## **SLAE Written Representation Submission for Deadline 9 - Construction**

This Written Representation reviews and comments on the five Construction titled documents.

### **TR020001-002894-5.02 Environmental Statement Appendix 4.1 Construction Method Statement and Programme Report**

### Inset 4.1: Assessment Phase 1 Construction Compounds Potential Locations

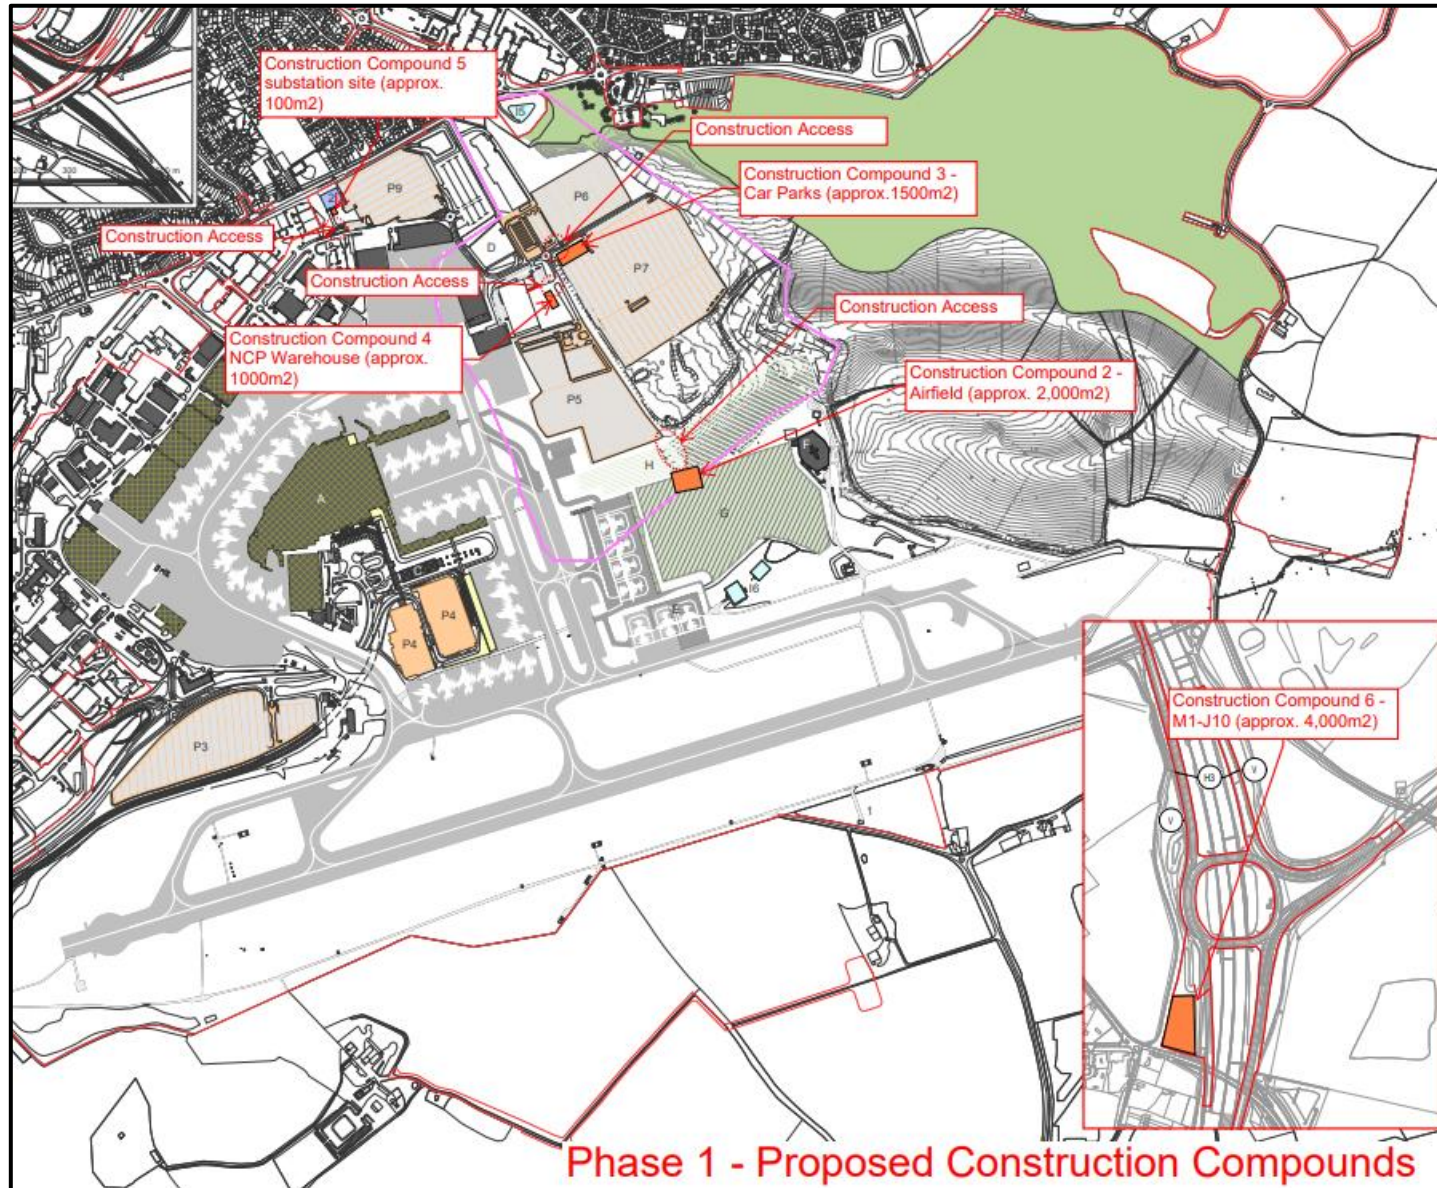
Why is it not clear when viewing the drawings in Appendix B, which Construction compounds apply to which areas? SLAE ask for clearer detail references in both text and drawings. For example, paragraph 4.3.3a. describes Construction Compound 1, which is to be located on the Replacement Open Space Wigmore Valley Park for year 1 (drawing on page 125), but the estimated Time Operational in Table 4.1 shows 24 months, and this is not shown on the drawing on page 126. It is also not shown on the drawing in Insert 4.1 on page 21.

### Inset 4.6: Assessment Phase 1 Earthworks (proposed area of cut)

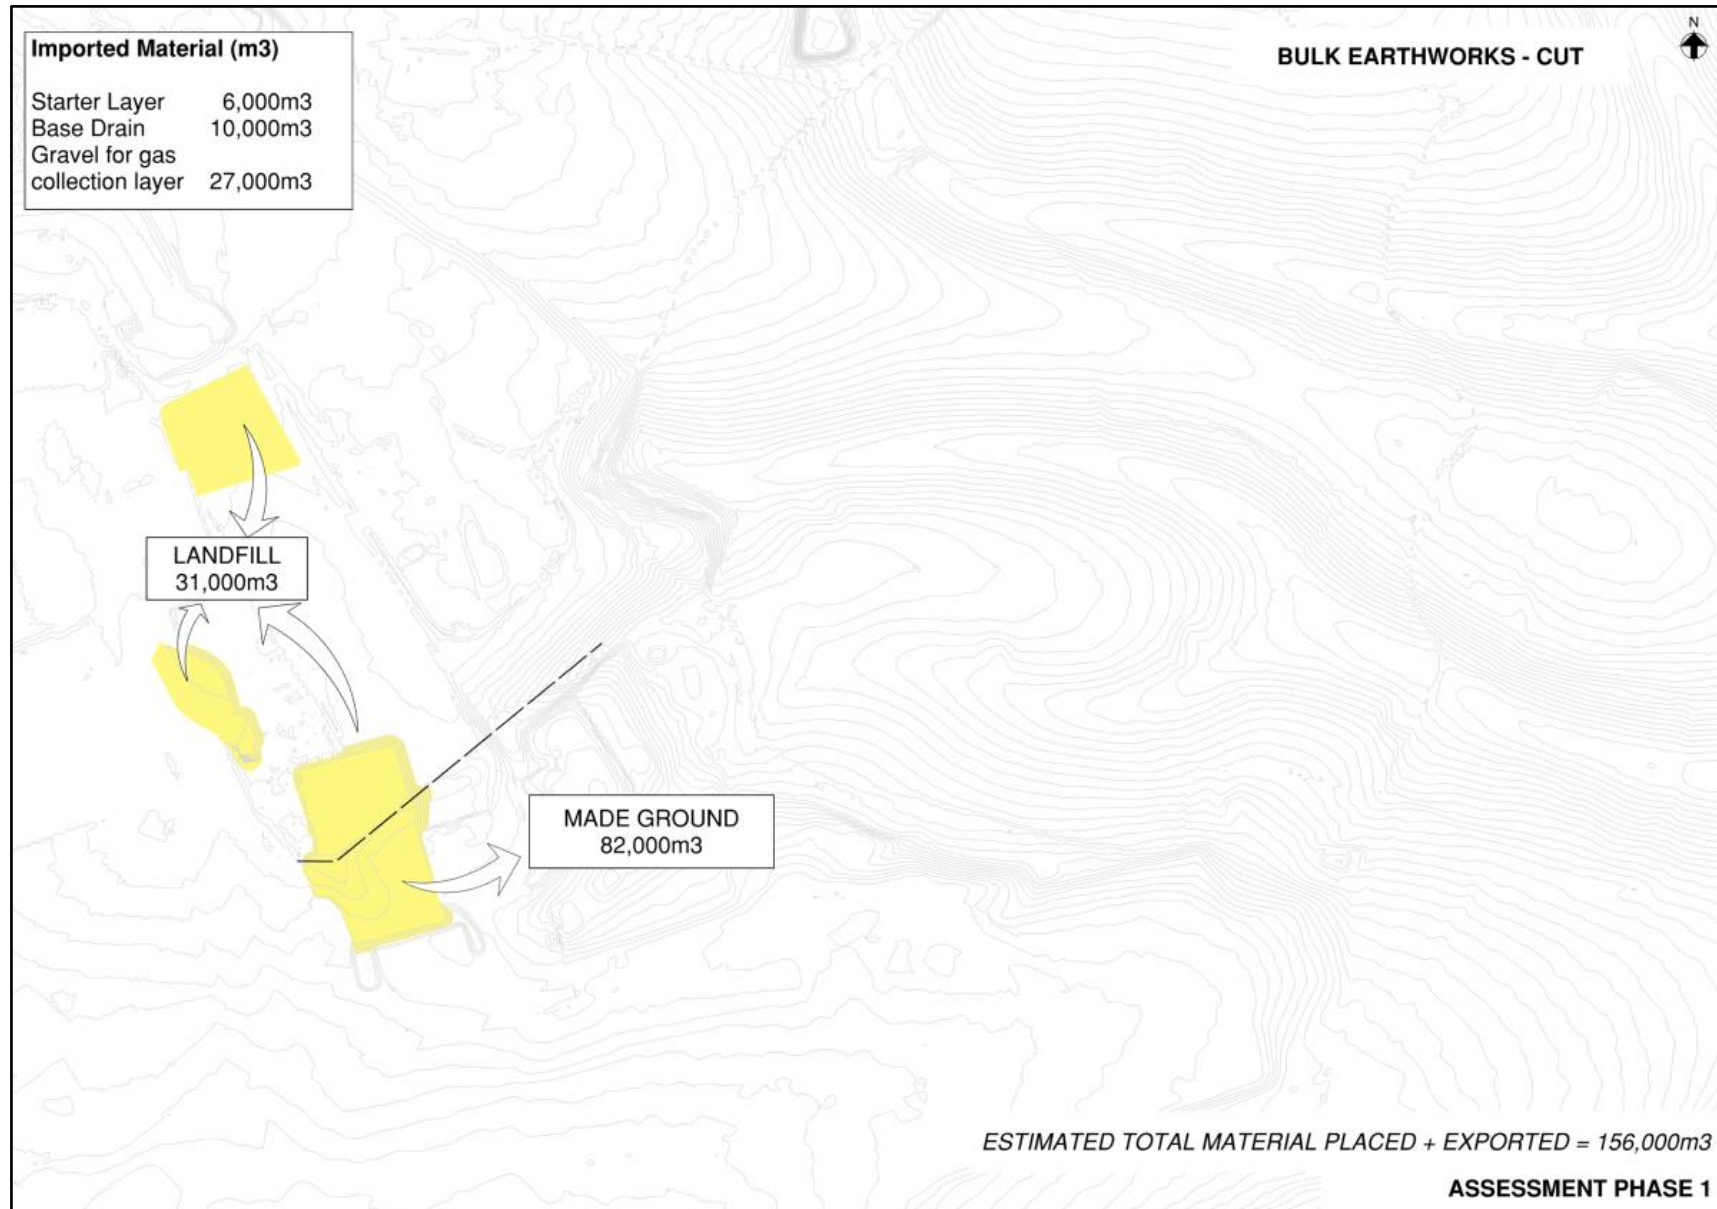
It is not possible to submit a response based upon the diagrams, Inset 4.6: Assessment Phase 1 Earthworks (proposed area of cut) and Inset 4.7: Assessment Phase 1 Earthworks (proposed area of fill). Why are LR using poor reproductions?

Why are there no easily recognised reference points shown on the diagrams.

### Inset 5.3: Assessment Phase 2a Earthworks (proposed areas of cut)

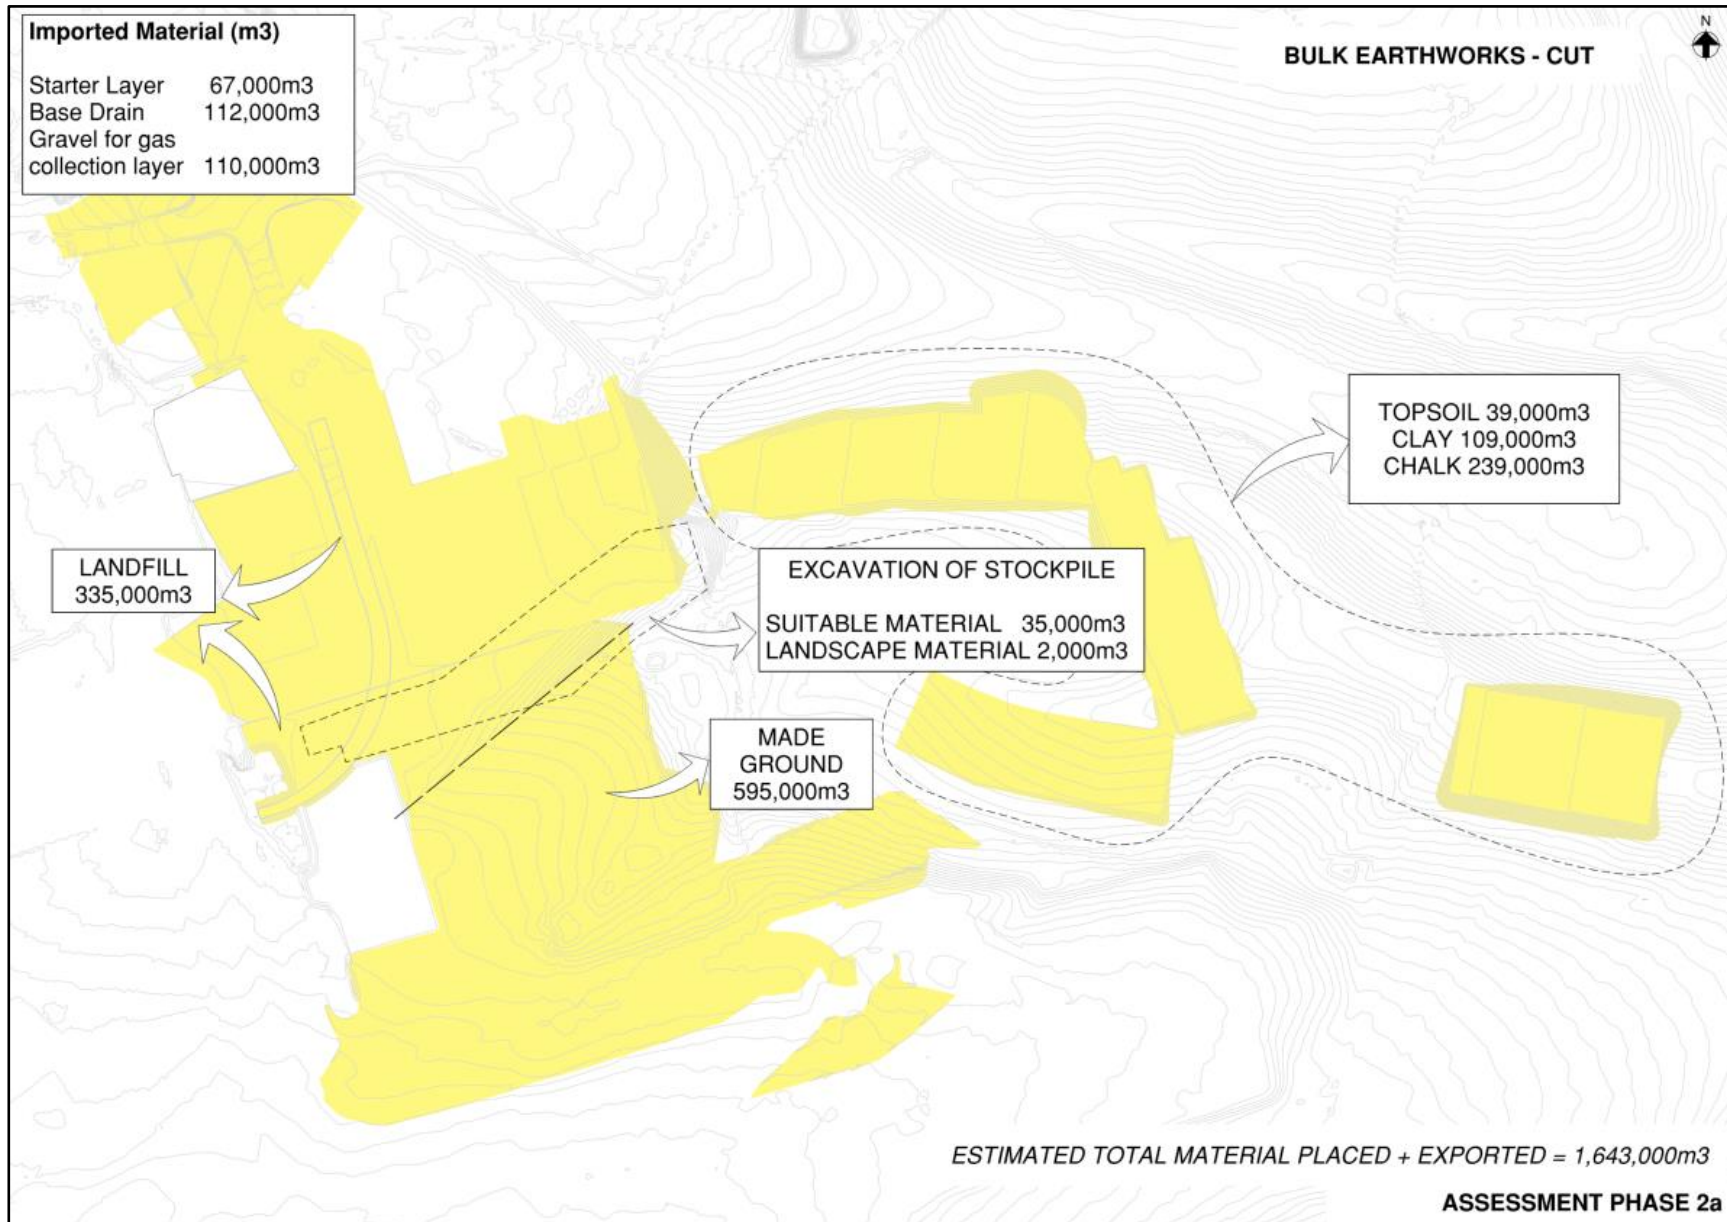
This also applies to those other diagrams shown in this document such as, Inset 5.3: Assessment Phase 2a Earthworks (proposed areas of cut), 5.3.27 The inset below shows areas of existing ground that excavated material would be deposited, 6.2. and 6.3.

Inset 5.32: Airport Access Road (proposed alignment)

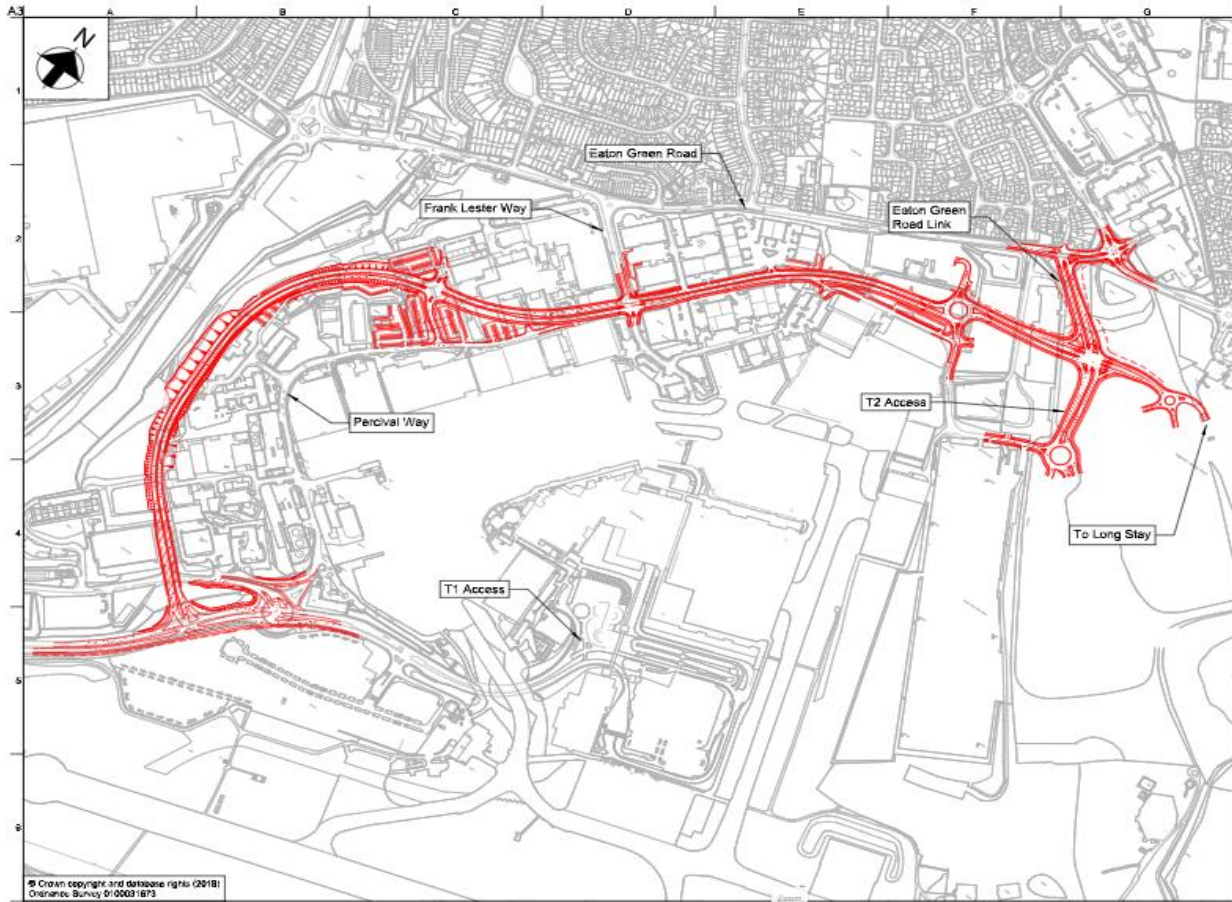
It appears that inset 4.33 and 4.34 are missing from this document, could LR identify which Environment Statement document these insets can be found? SLAE will then be able to respond by a future deadline date.

Inset 5.36: Assessment Phase 2a Car Park Locations

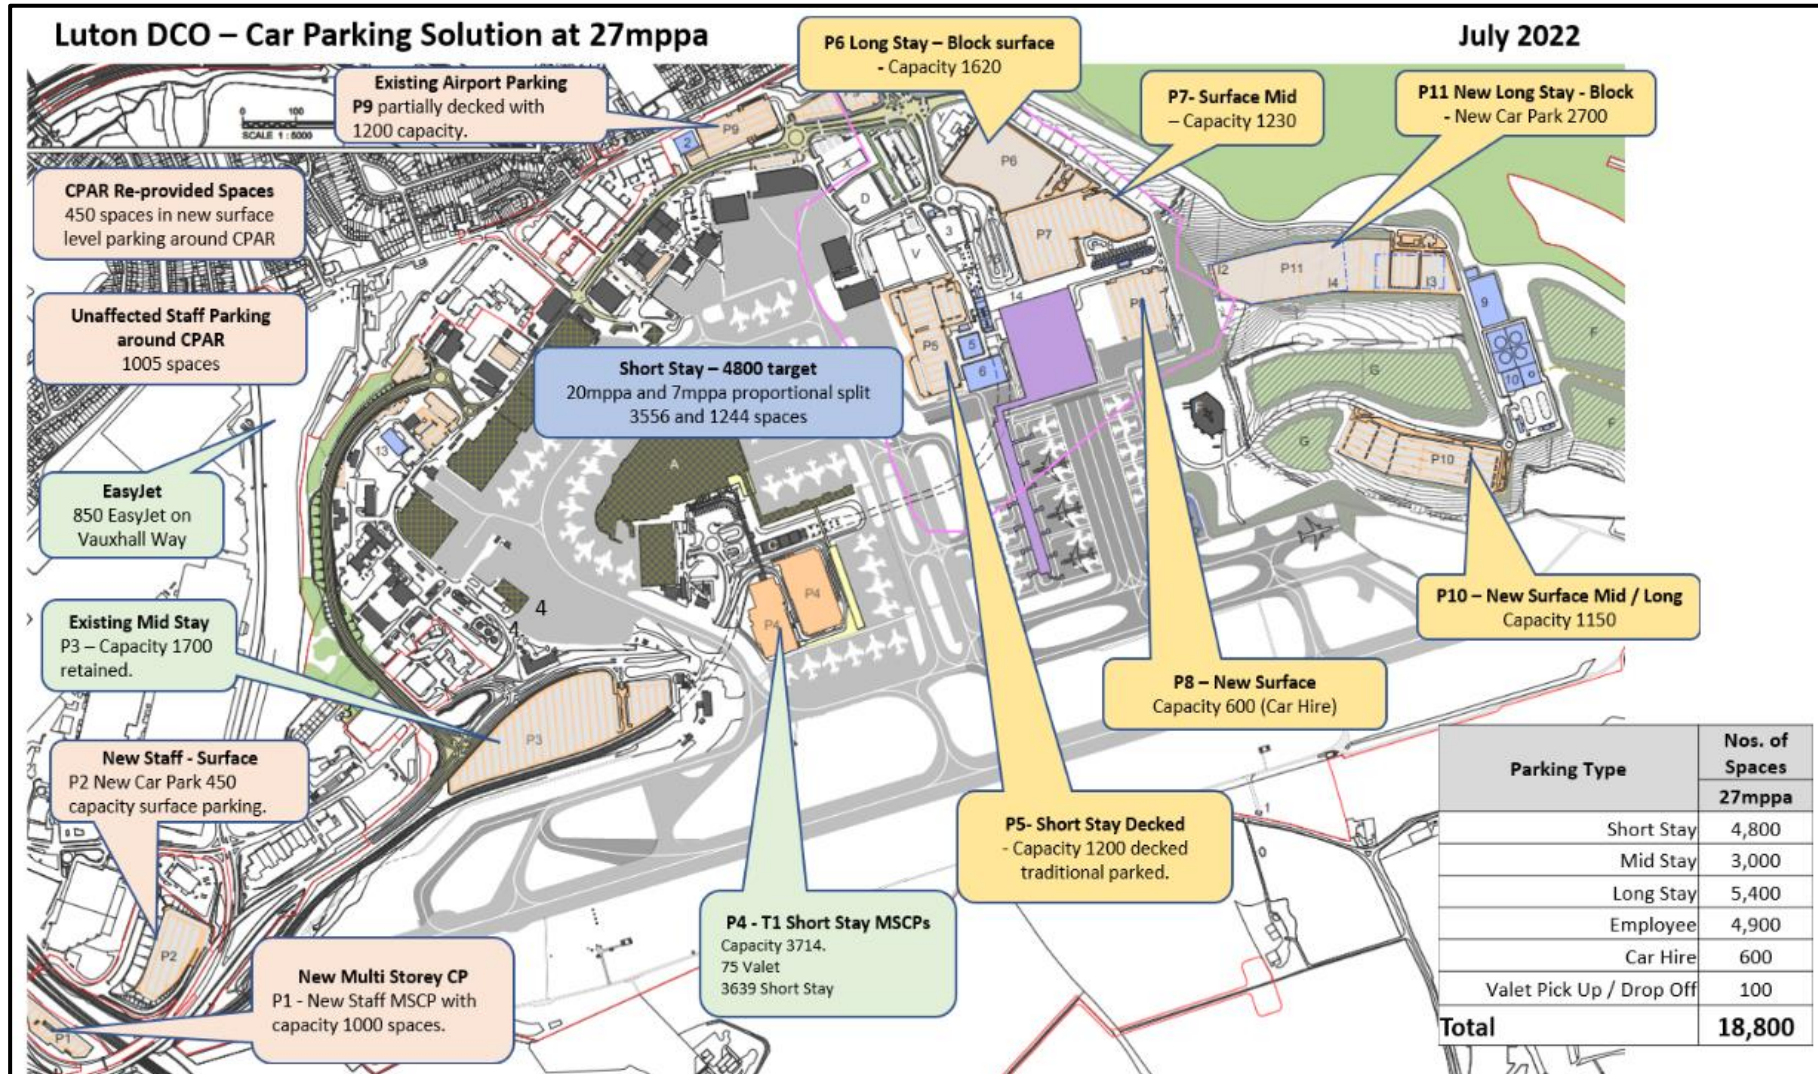
How can LR justify the destruction of the current Wigmore Valley Park and the County Wildlife Site for the building of so many car parks?
